### MERCURY RENEWABLES (CARROWLEAGH) LIMITED

## FIRLOUGH WIND FARM, CO. MAYO AND HYDROGEN PLANT, CO. SLIGO

# RESPONSE TO MAYO COUNTY COUNCIL SUBMISSION PLANNING APPLICATION REFERENCE ABP-317560-23

### March 2024

Figure 12.12: Map 1 – Wind Energy relative to the site, derived from Renewable Energy Strategy for Co. Mayo 2011–2020

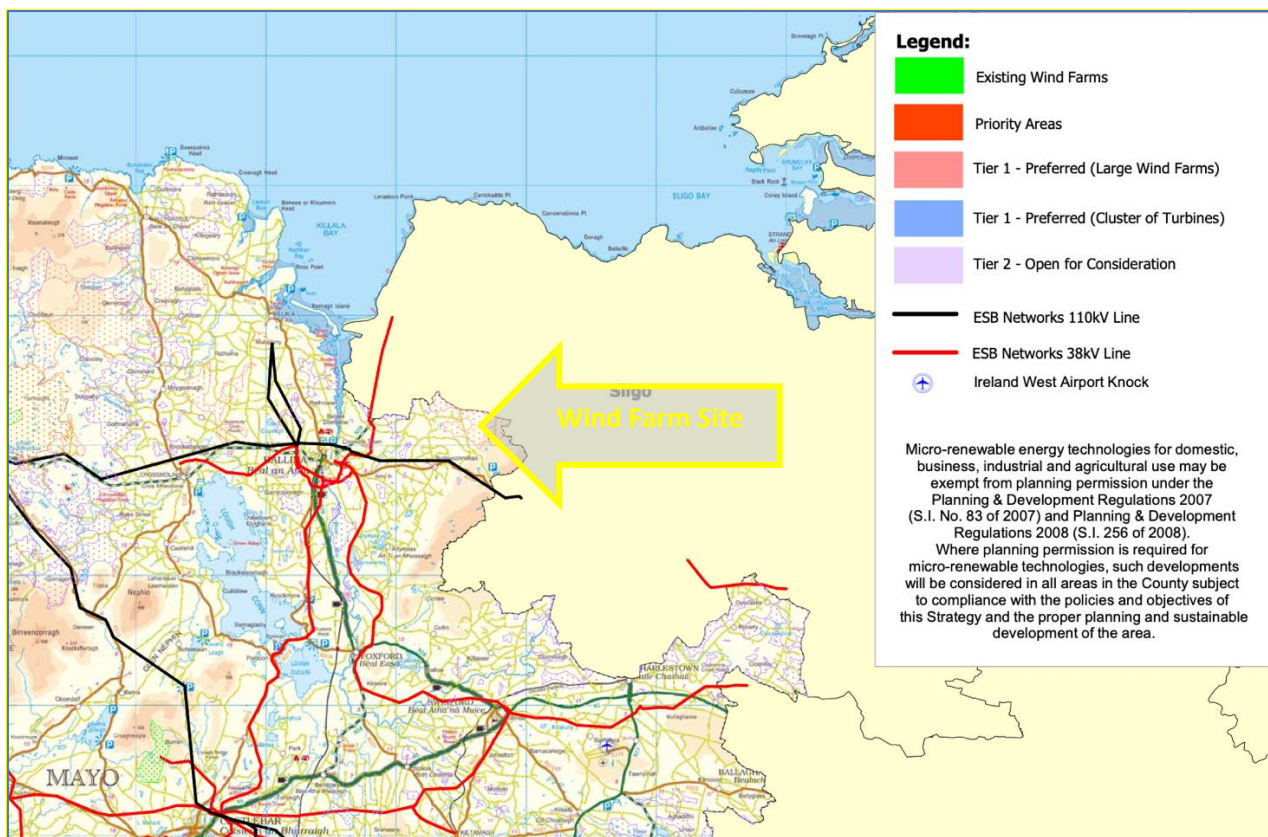
Map 1 Wind Energy details location In the County where wind farms will be considered. See extract from map below Map 1

It should be noted that Mayo County Council adopted the renewable energy strategy in 2011 when turbines where considerably smaller in height and less imposing on the landscape compared to modern turbines. Comparing the turbines at this location with the proposed development.

Mayo County Council is in the process of commencing a review of the current renewable energy strategy with the potential visual impact of new technological advances and increased turbine sizes considered in this review, Therefore, the areas Identified as preferred locations within the current strategy may change over the course of this review.

This is noted, the Project has been assessed based on the policy of the County Development relevant to the period in which the application was lodged.

The proposed Firlough Wind Turbines are all contained in a wind deployment zone for Tier 1-Large Scale Wind Farms within the Mayo Renewable Energy Strategy (2011), which was brought through unchanged into the latest County Development Plan (2022-2028). The Mayo Renewable energy strategy 2011 highlights in section 6.4 – 'Location of Renewable Developments', the extensive sieve mapping exercise of environmental constraints and wind speed opportunity that was used to determine wind energy deployment zones at that time. There is no reason to believe that a similarly robust exercise, undertaken as part of a revision of the Mayo Renewable Energy Strategy, would result in marked variations to the wind deployment zoning in this area. Indeed, it is considered that from a landscape and visual perspective, the broad scale and productive character of the receiving landscape, which already contains wind turbines, can readily absorb the proposed development for many of the same reasons it is currently zoned Tier 1 – large Wind Farms. This is reflected in the findings of the project LVIA in Chapter 12 of the EIAR.
